KIRKLEES METROPOLITAN COUNCIL INVESTMENT & REGENERATION SERVICE

Reference No: 2021/70/92298/E

Site Address: Dry Hill Farm, Dry Hill Lane, Denby Dale,
Huddersfield, HD8 8YN

Description: Variation of condition 2. (plans) on previous
permission no. 2018/90187 for Change of use and
alterations to existing agricultural barn to form dwelling

PROPOSED FIRST FLOOR PLAN 1:50 @ A1

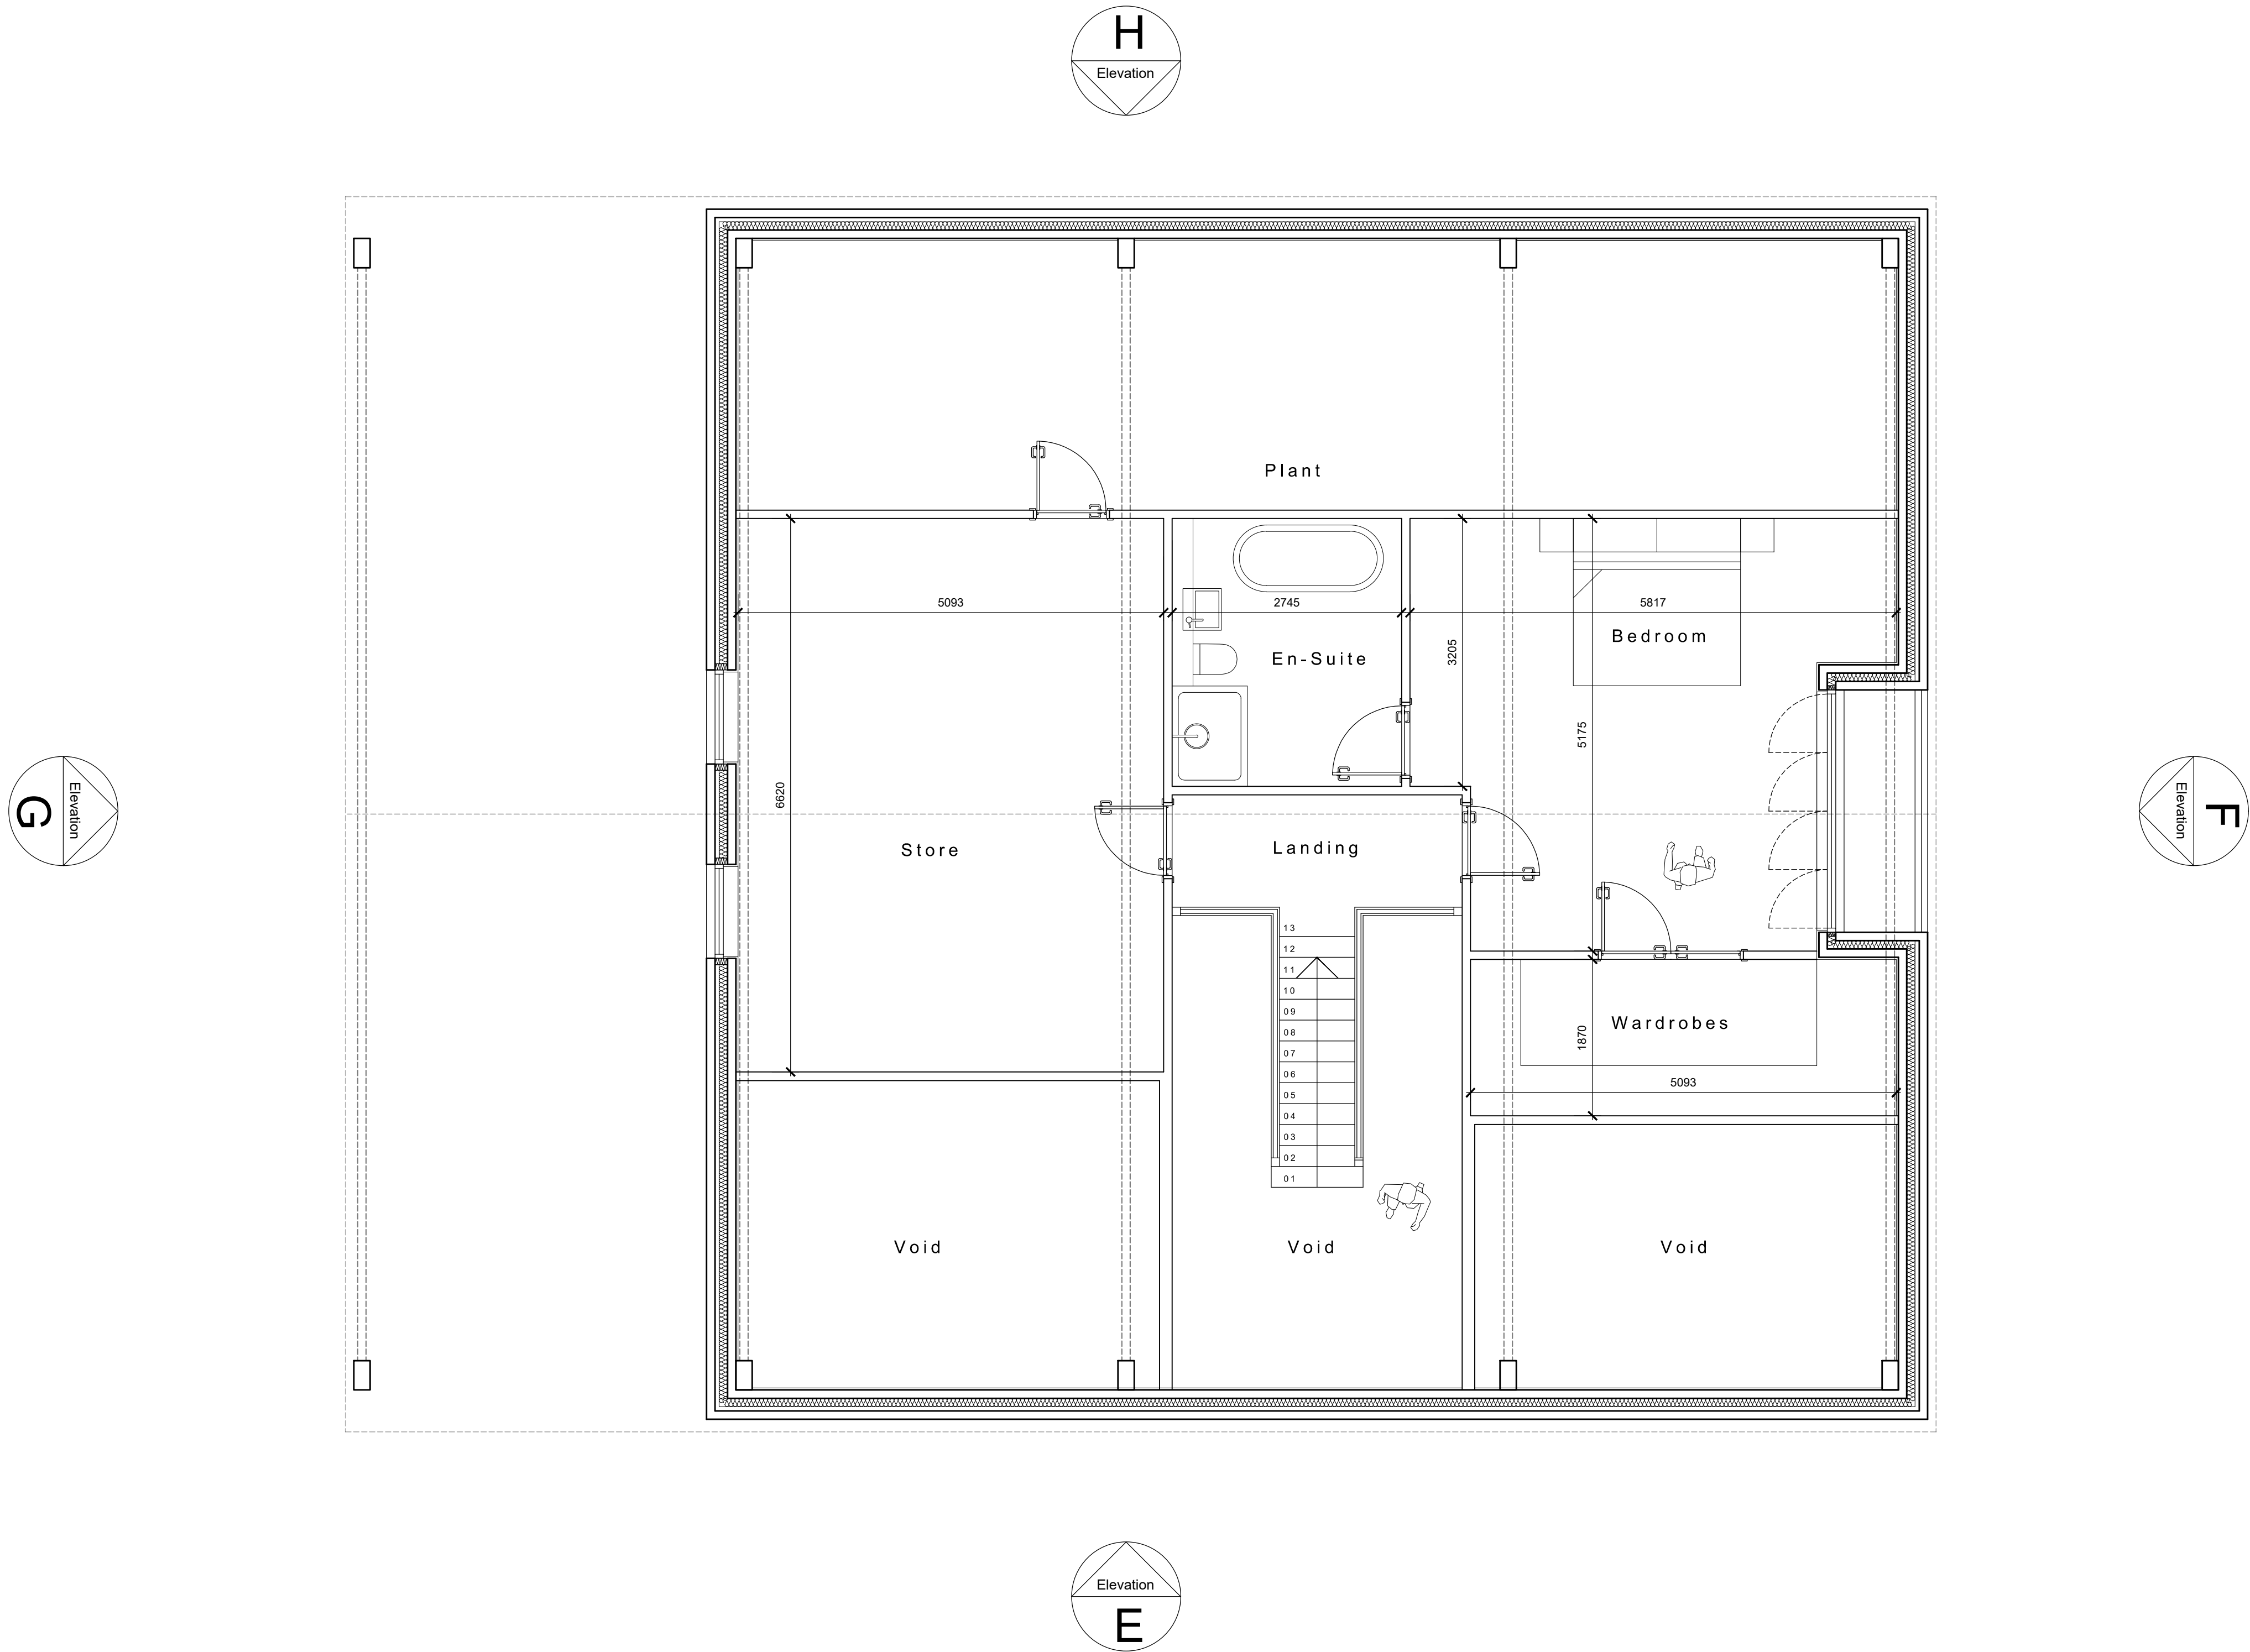
- *Removal of garage to create snug and bathroom*
- *Reconfiguration of ground floor layout*
- *Additional room at first floor to create storage room*

PROPOSED GROUND FLOOR PLAN 1:50 @ A1

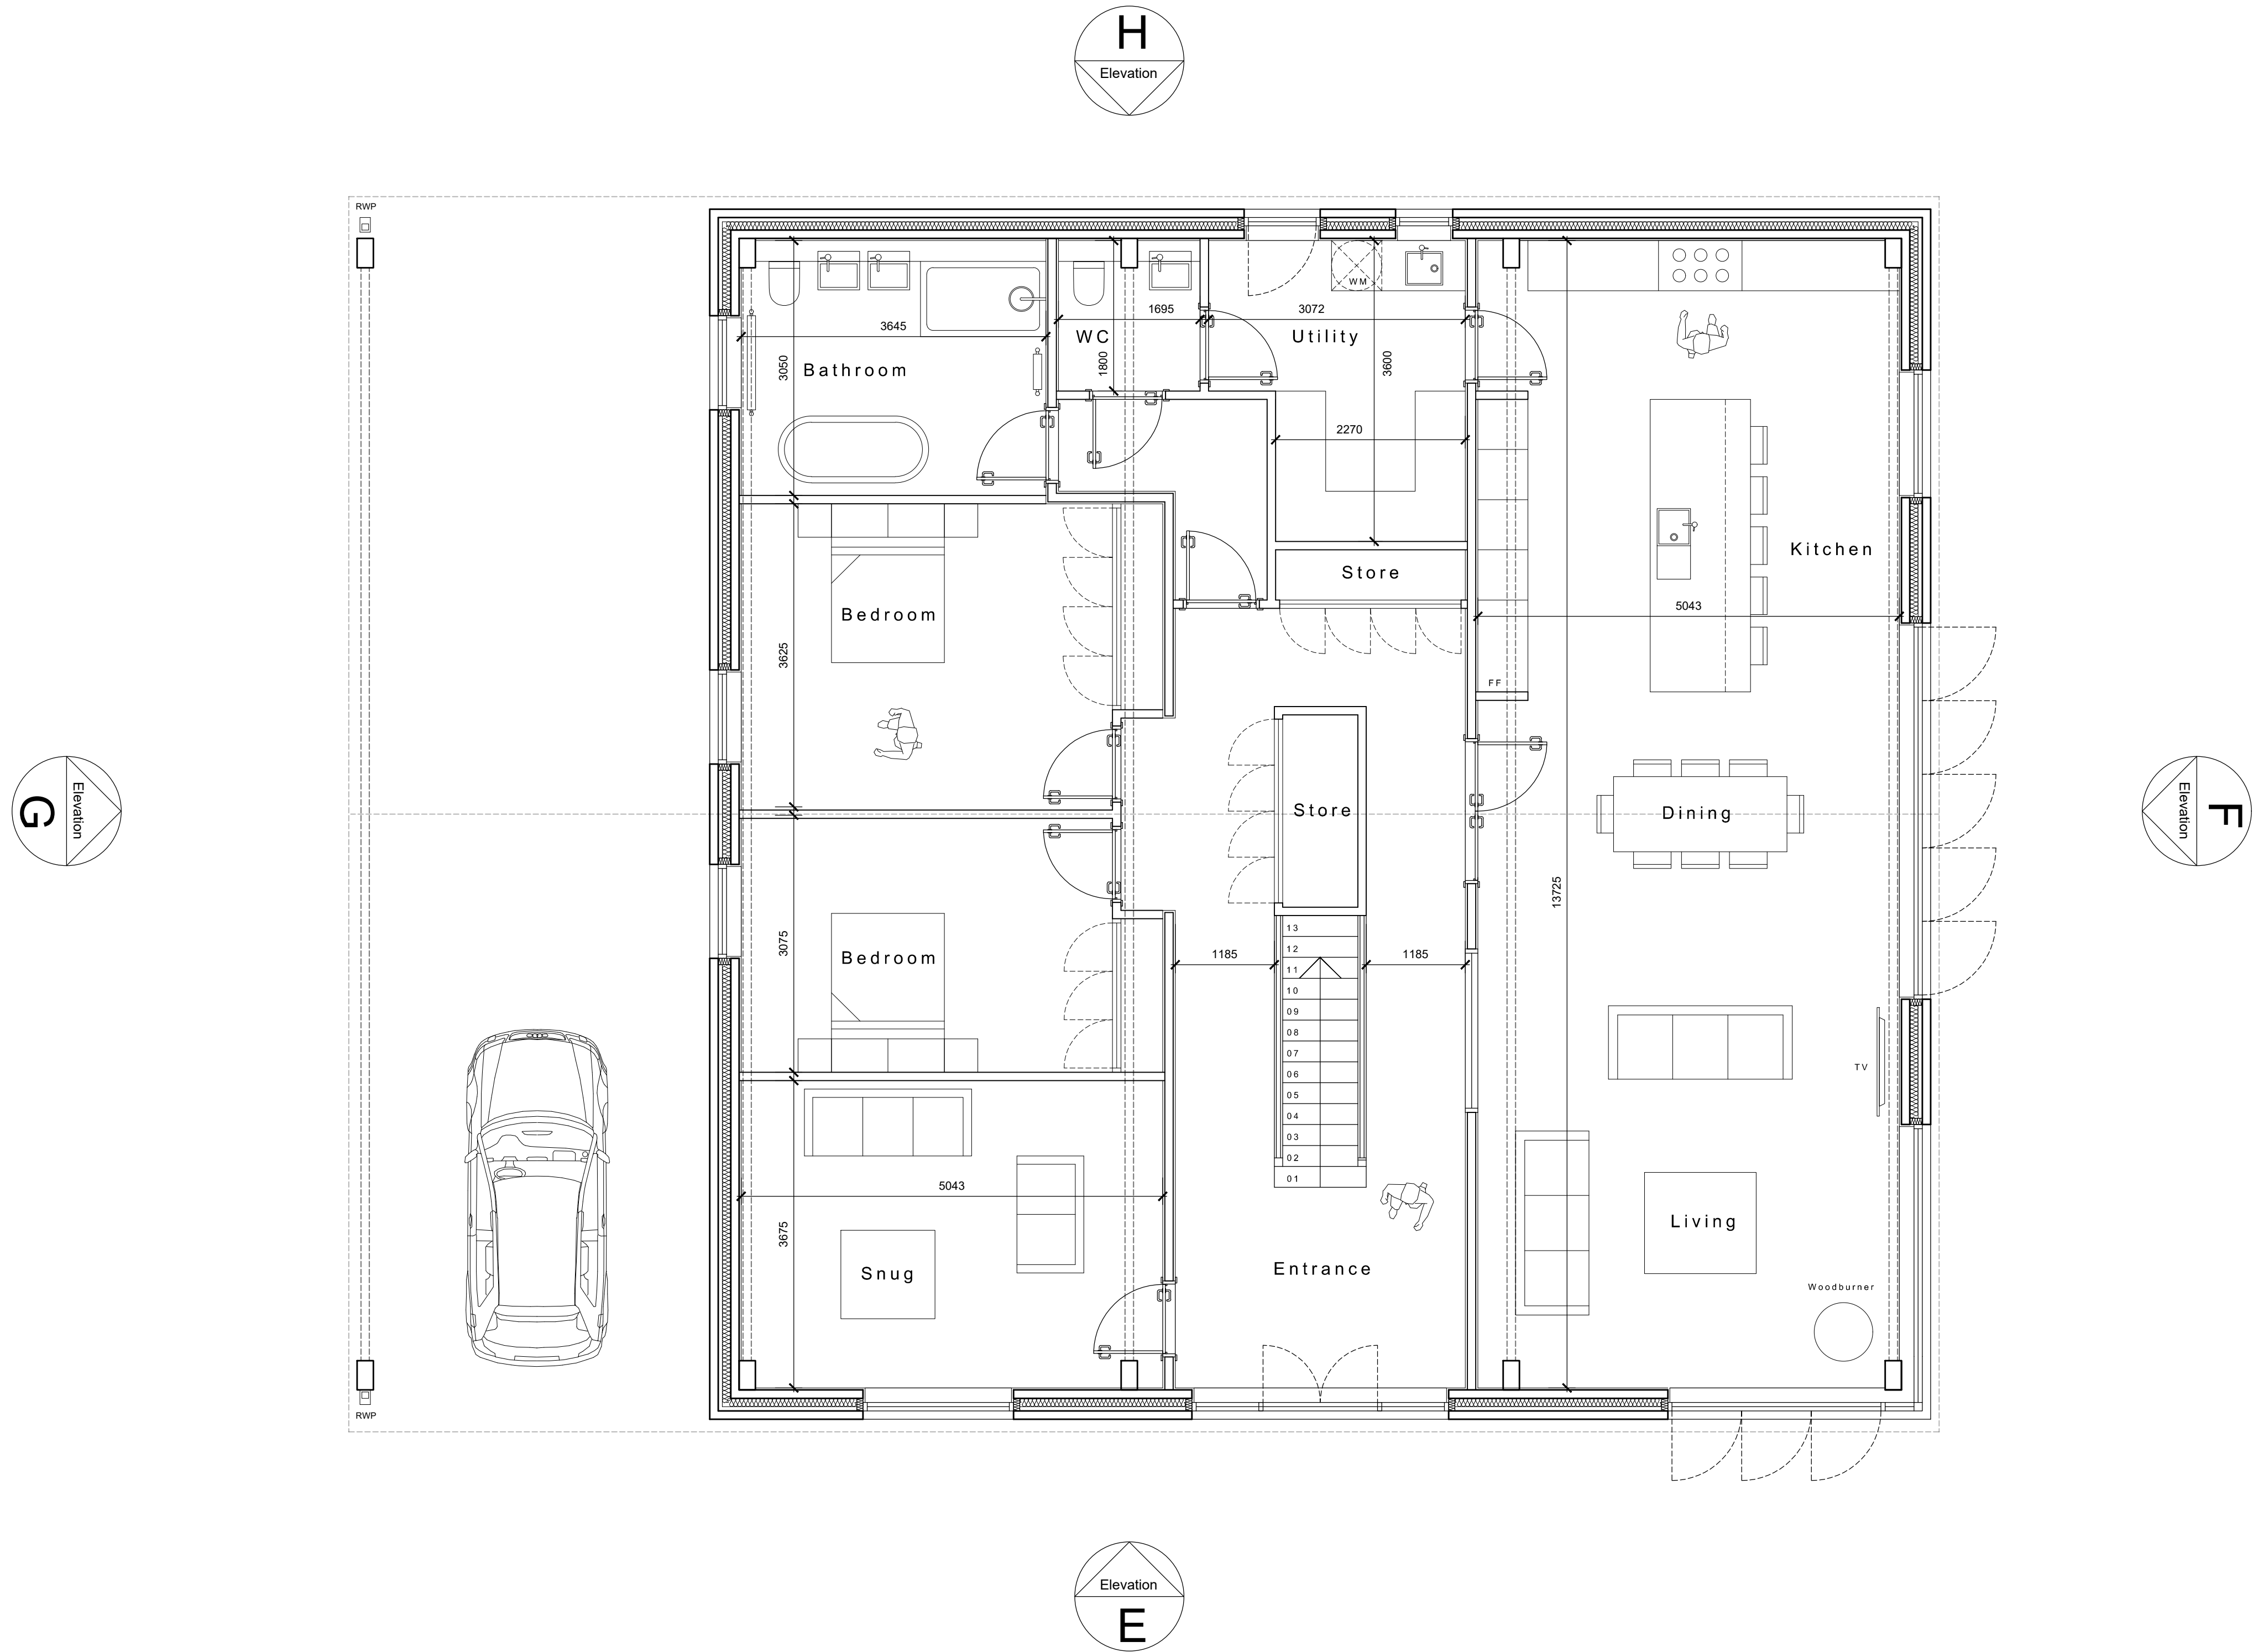
The proposal removes the integral double garage. However, parking is proposed to the west of the building, under the existing canopy roof. As such, the level of parking at the site is retained. Therefore, the proposal is in accordance with policies LP21 and LP22 of the KLP.
